Subject: Rezoning Petition Review

Rezoning Petition #: 21-239

Location of Property: Approximately 9.34 acres located on the west side of E WT Harris Blvd, north of District Dr and the east side of Shorthorn St.

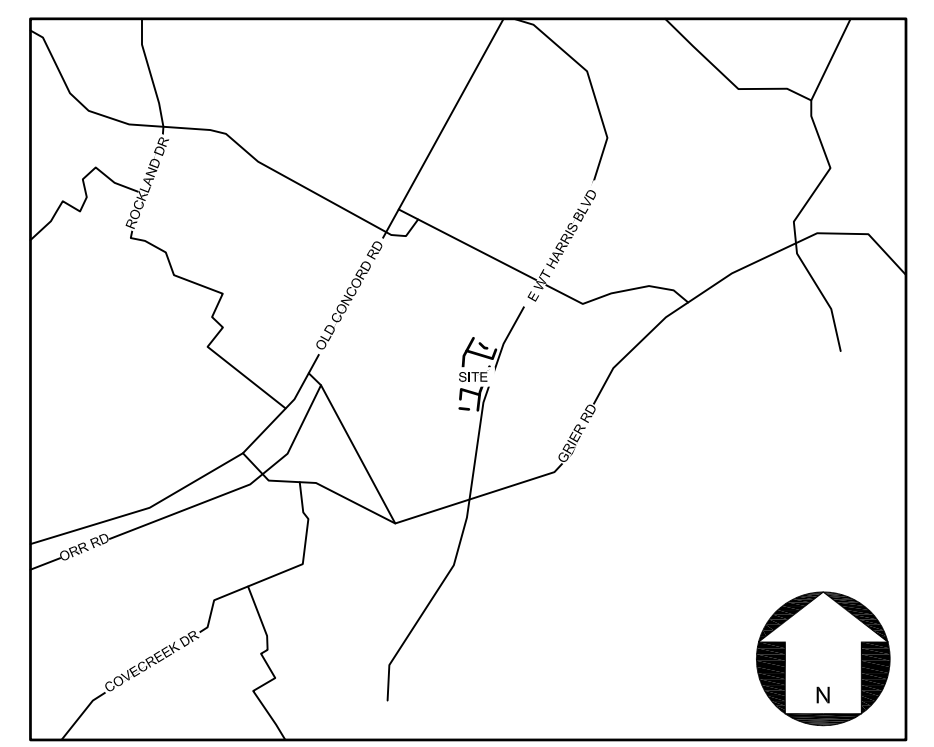
City of Charlotte GIS data indicates a 100-ft Undisturbed PCSO buffer across the site. Please show and label *Potential 100-ft Undisturbed PCSO Buffer* on the site plan. Any increase of impervious area within such buffers may not be allowed and is not approved with the rezoning process. Please include the following note under Environmental Features: *“Development within any SWIM/PCSO Buffer shall be coordinated with and subject to approval by Charlotte-Mecklenburg Storm Water Services and mitigated if required by City ordinance. Petitioner acknowledges intermittent/perennial stream delineation reports are subject to review and approval upon submission of development plans for permitting and are not approved with rezoning decisions.”*
